Appendix 1

LITTLEHAMPTON TOWN COUNCIL
Planning & Transportation Committee Monday 15 February 2010
Representation on List 6

TITLE	
PROPOSED LAYOUT	
DATE	SCALE
17/11/2009	1:100
DRAWN	CHECKED
KEN

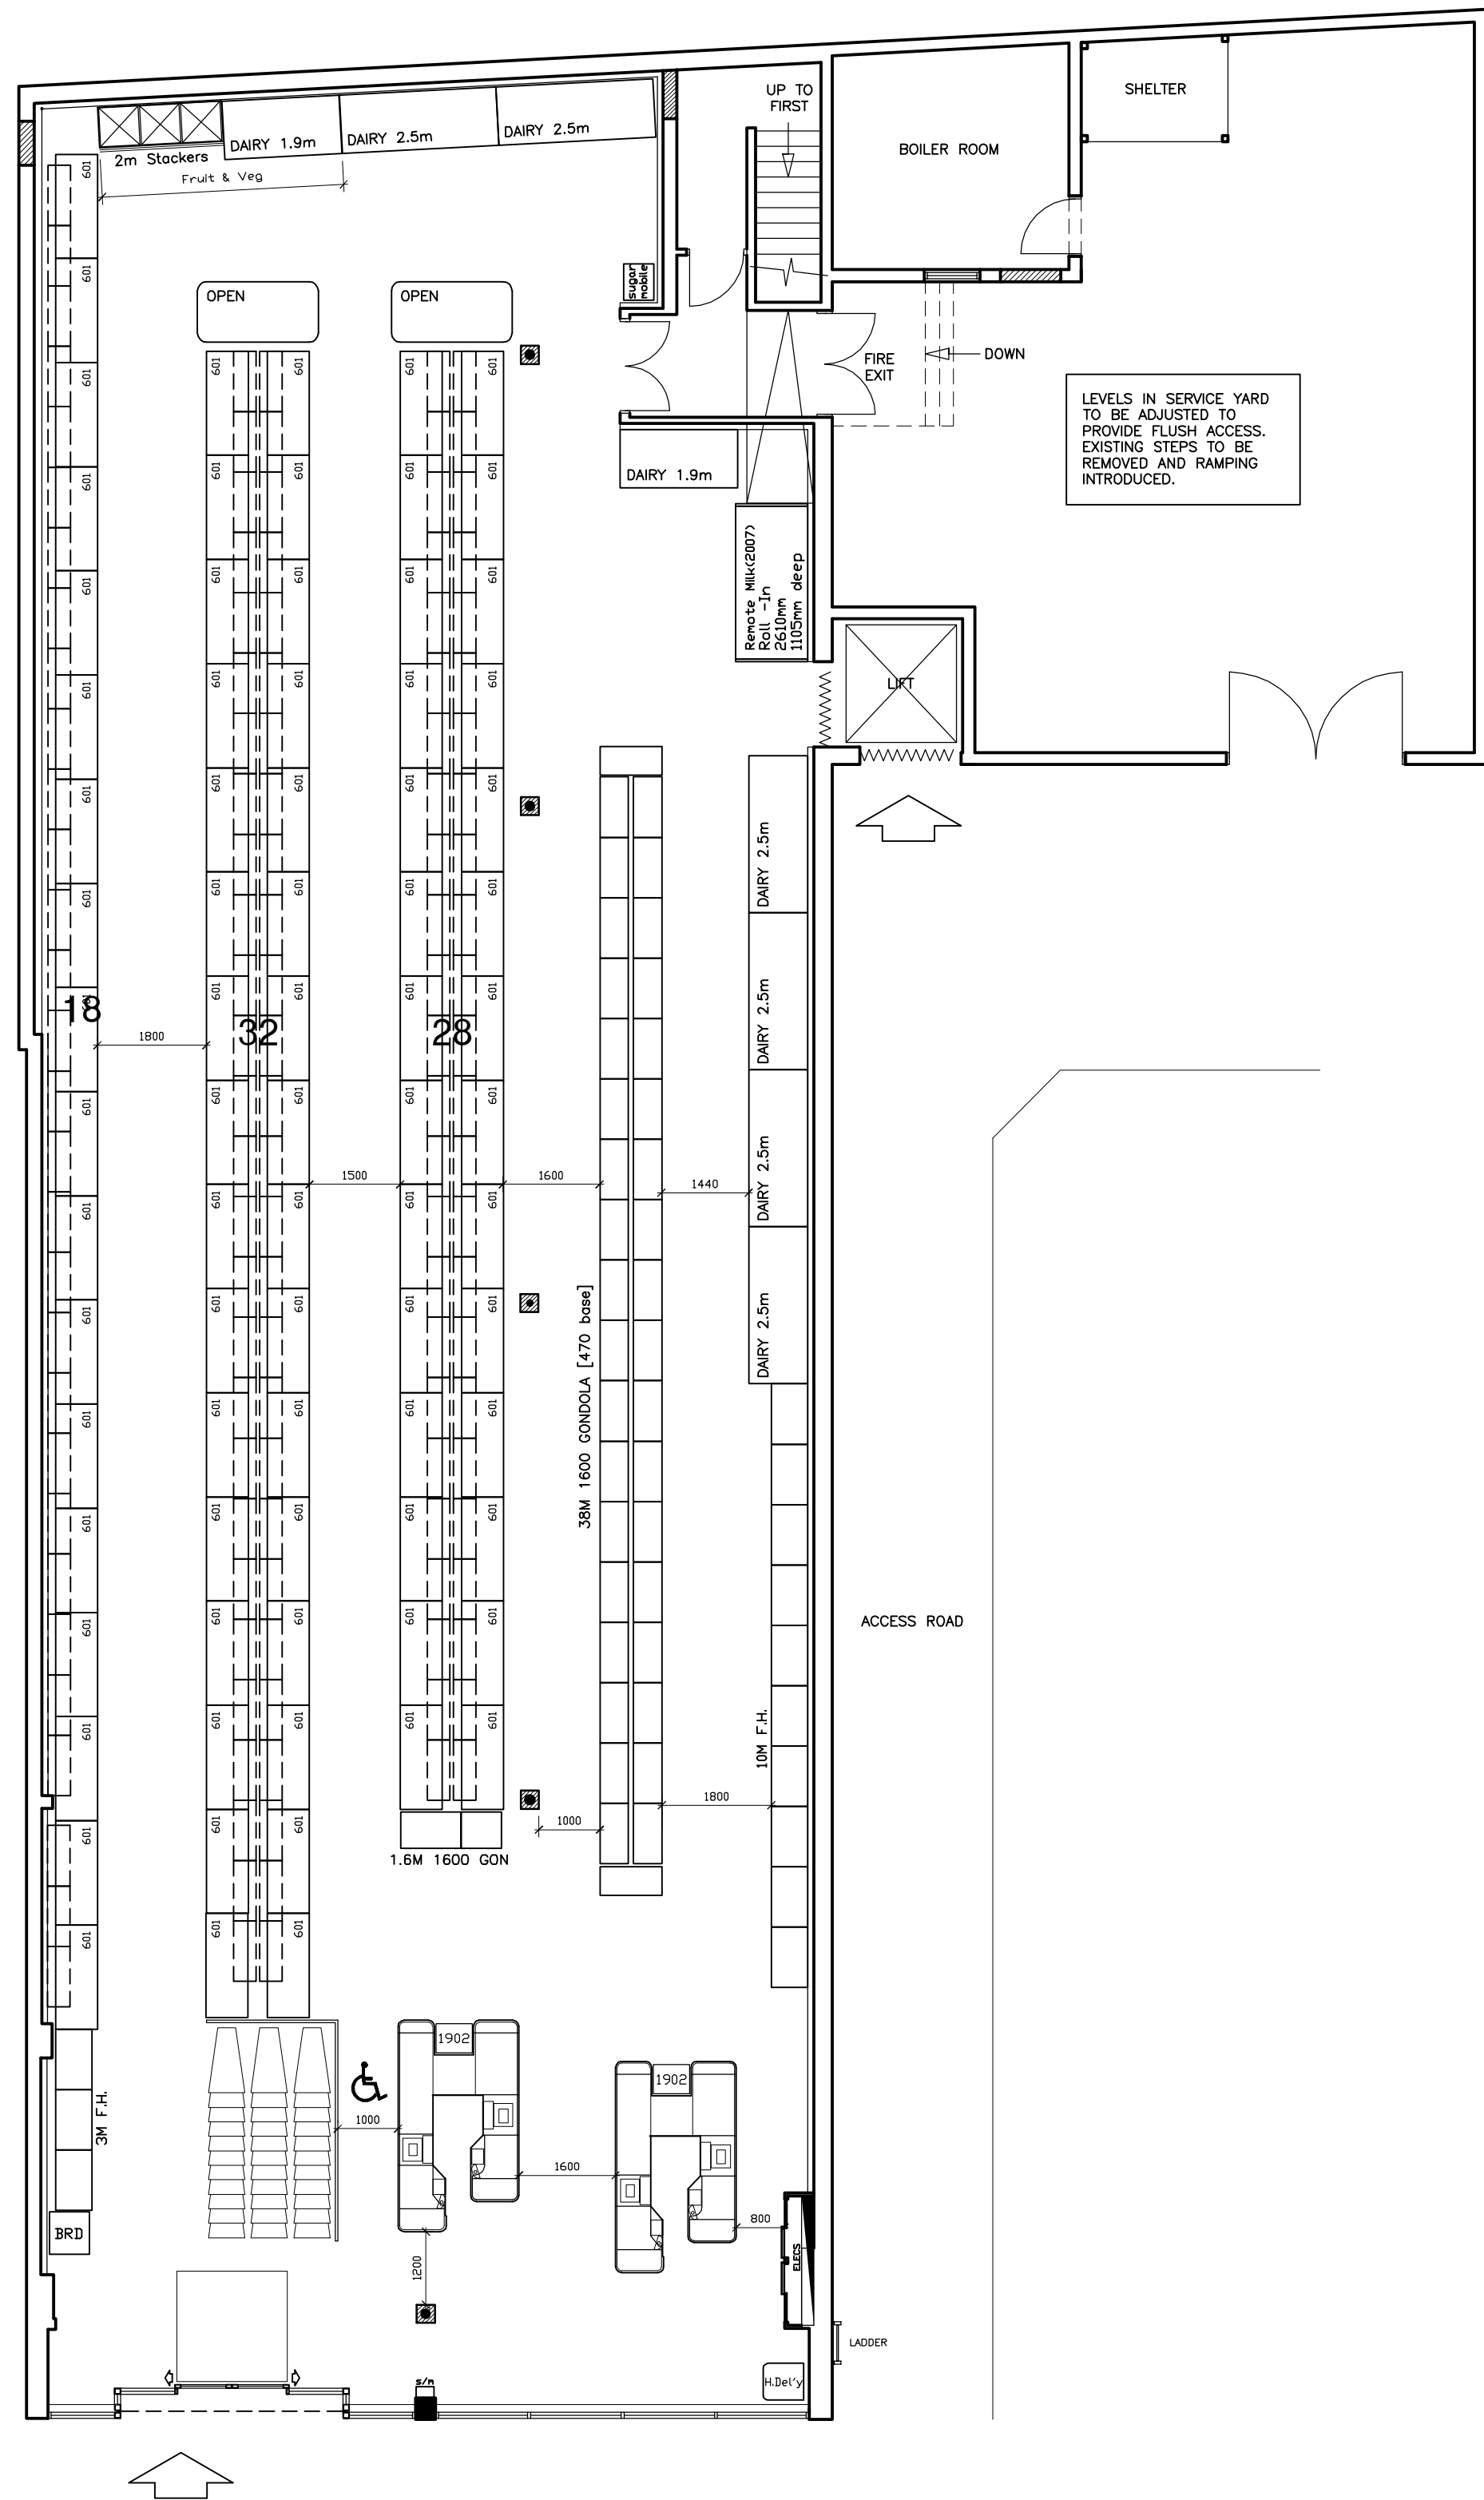
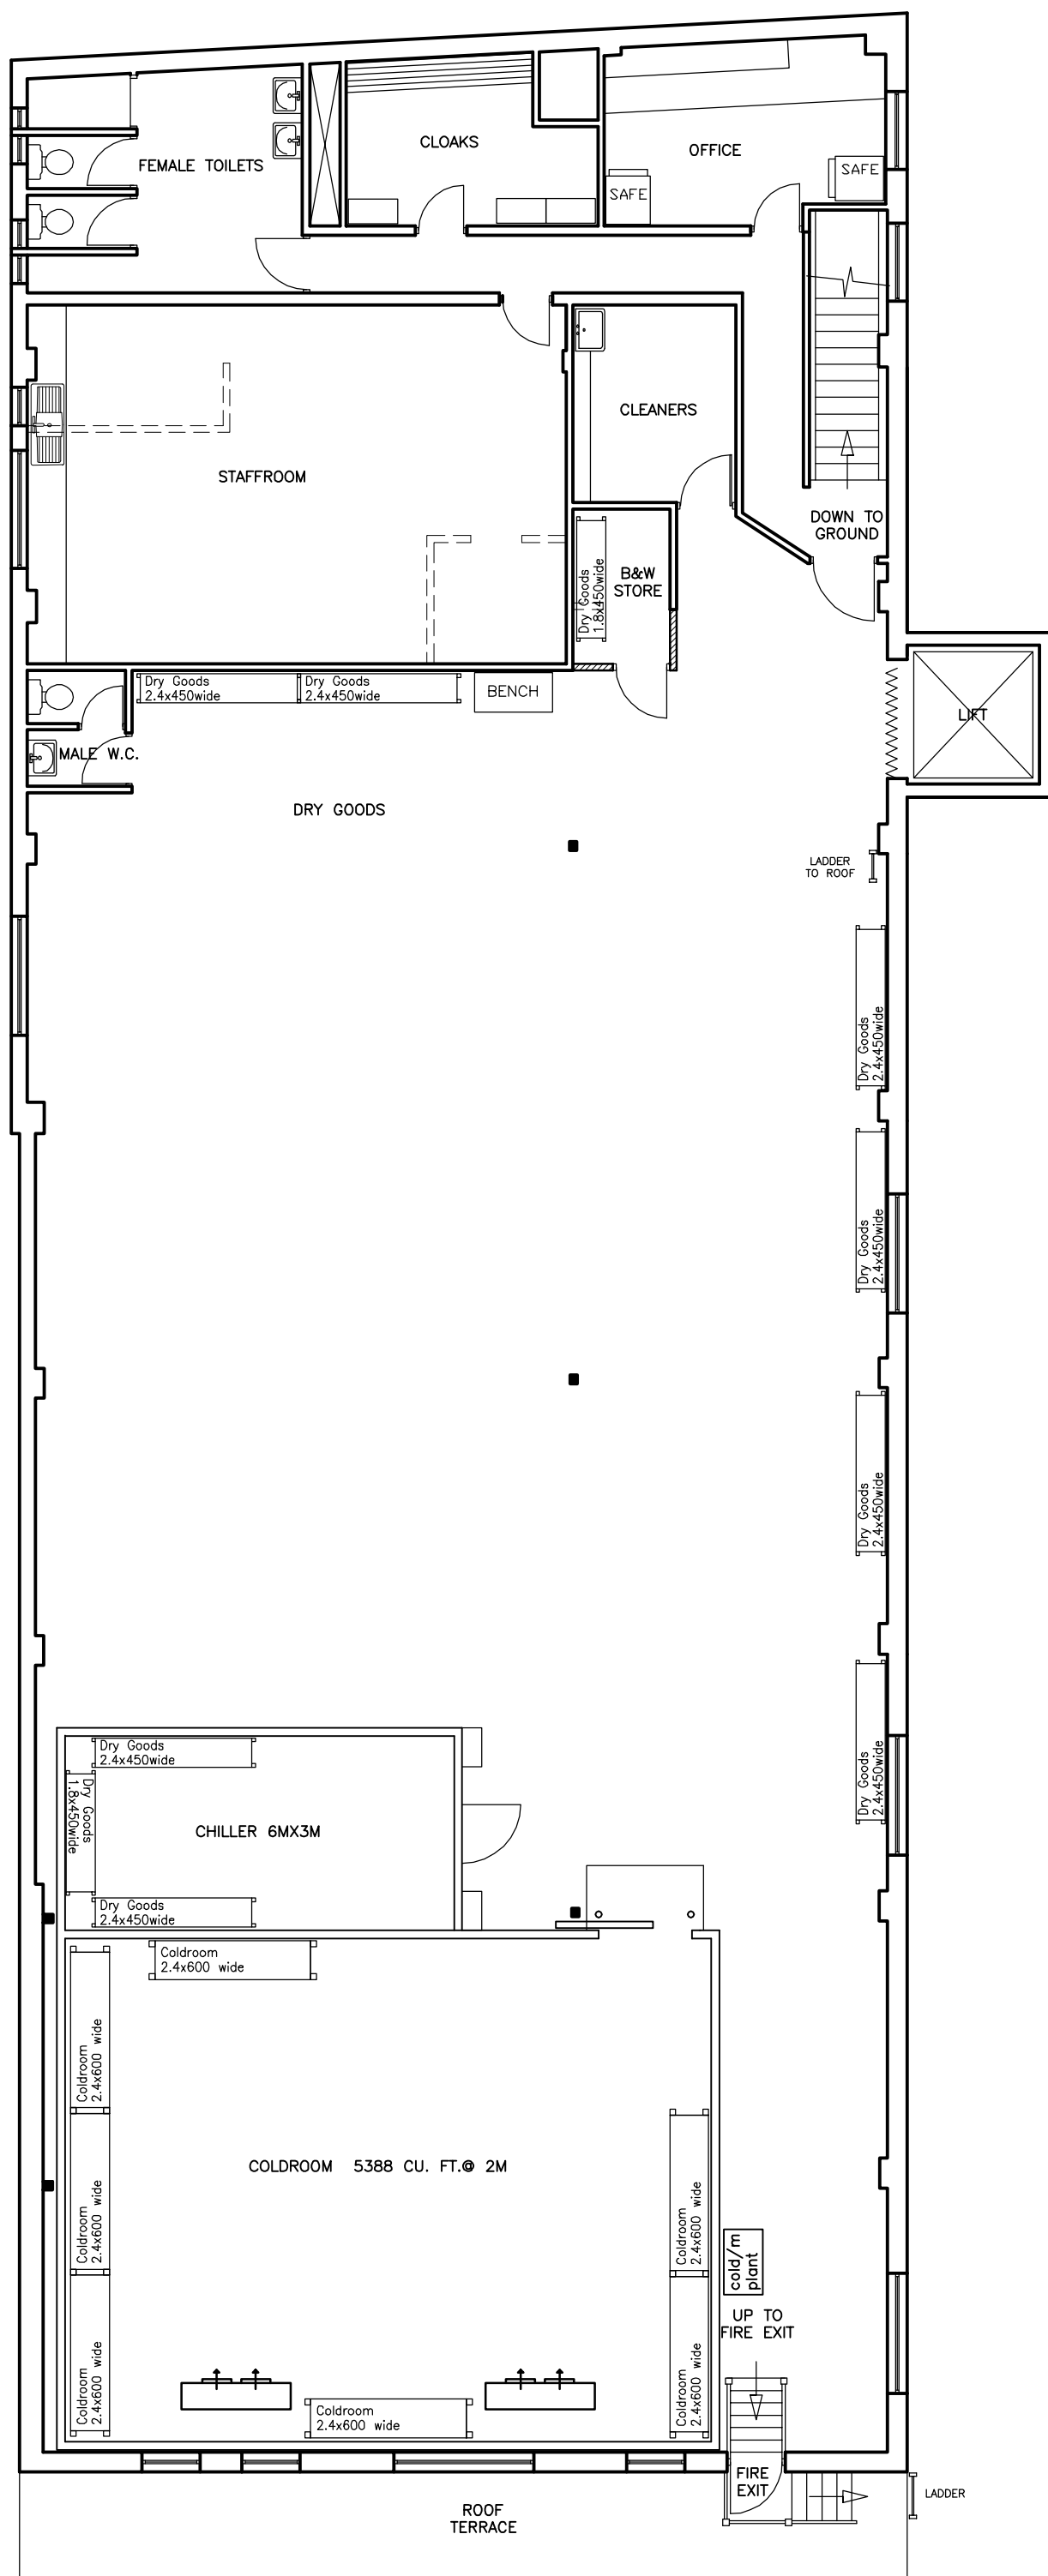
Plan List No.	Ward	Ward Councillor	Planning No.	Details of Application	Location	Comments
6	Wick with Toddington		LU/3/10	Retention of temporary polytunnels	Holland & Zuider Zee Nurseries Toddington Lane Littlehampton	No Objection
6	River	IB	LU/17/10	New shop front incorporating new customer entrance, grey render stall riser & pilasters & red punched & glazed roller shutter	19-23 Surrey Street	No Objection
6	River	IB	LU/22/10	Conversion of ground floor shop premises & first floor flat over into self contained terrace town house - Resubmission following LU/309/09	16 Bayford Rd Littlehampton	No Objection
6	River	IB	LU/26/10/A	1 no. internally illuminated fascia sign (new letters only) & 1 no. externally illuminated hanging sign	19-23 Surrey Street	No Objection, but the Town Council strongly believes that all illuminated signs should be switched off during the hours when they are not needed, ie. the small hours of the night. This does not preclude the use of illuminated signs, just their hours of use. This applies to all applications relating to illuminated signage.
